RE: Intake Screening- 2206-099  
Project: 9167 SE 64<sup>th</sup> st new SFR.

Please find our responses to your intake comments:

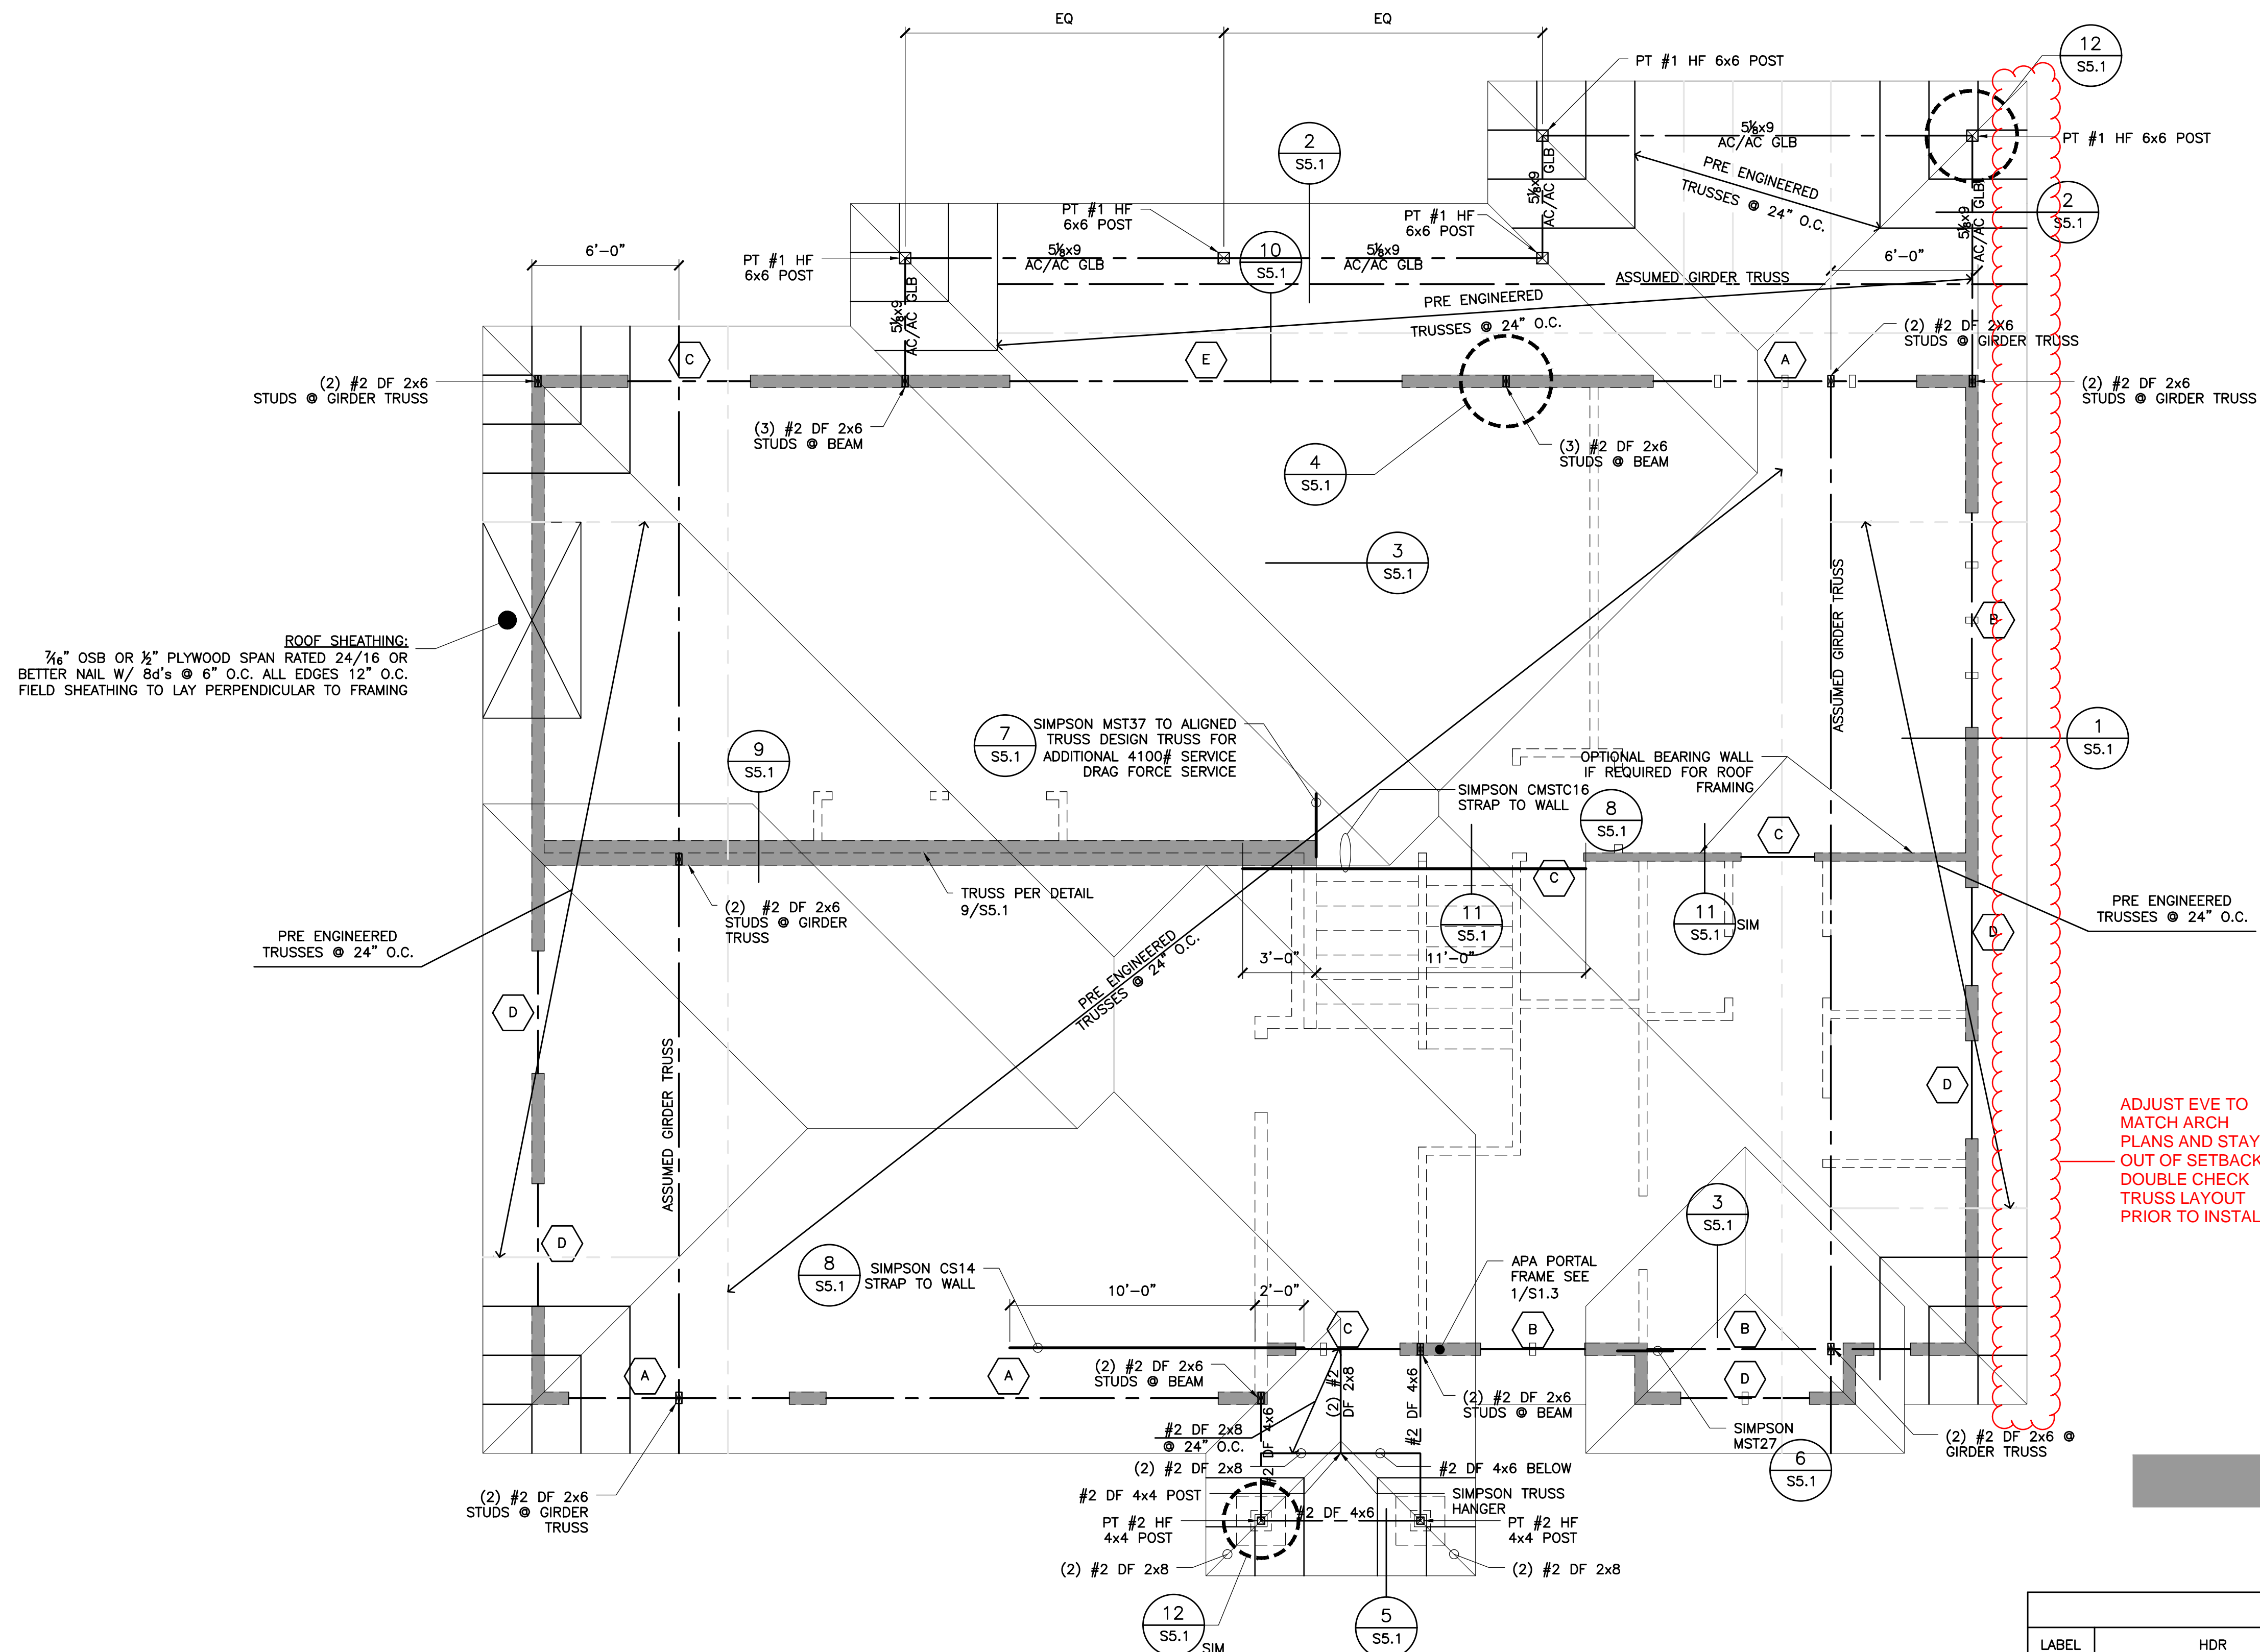
8. Andrew Leon- The plans show that the eaves of the house are proposed to penetrate into the 10-foot side-yard setback from the west property line. The elevations show that the wall facade of the west side of the house exceeds 25 feet in height. Under MICC 19.02.020(C)(1)(c)(iii)(b), a 10-foot minimum side yard setback from a property line is required when a wall facade abutting that property line exceeds 25 feet in height. MICC 19.02.020(C)(3)(a)(ii) prohibits eaves from penetrating into minimum side yard setbacks, so the eaves will need to be revised to remove the penetration.  
*We revised the eaves on the west side of the house to be 9" so they would not be in the setback any longer.*
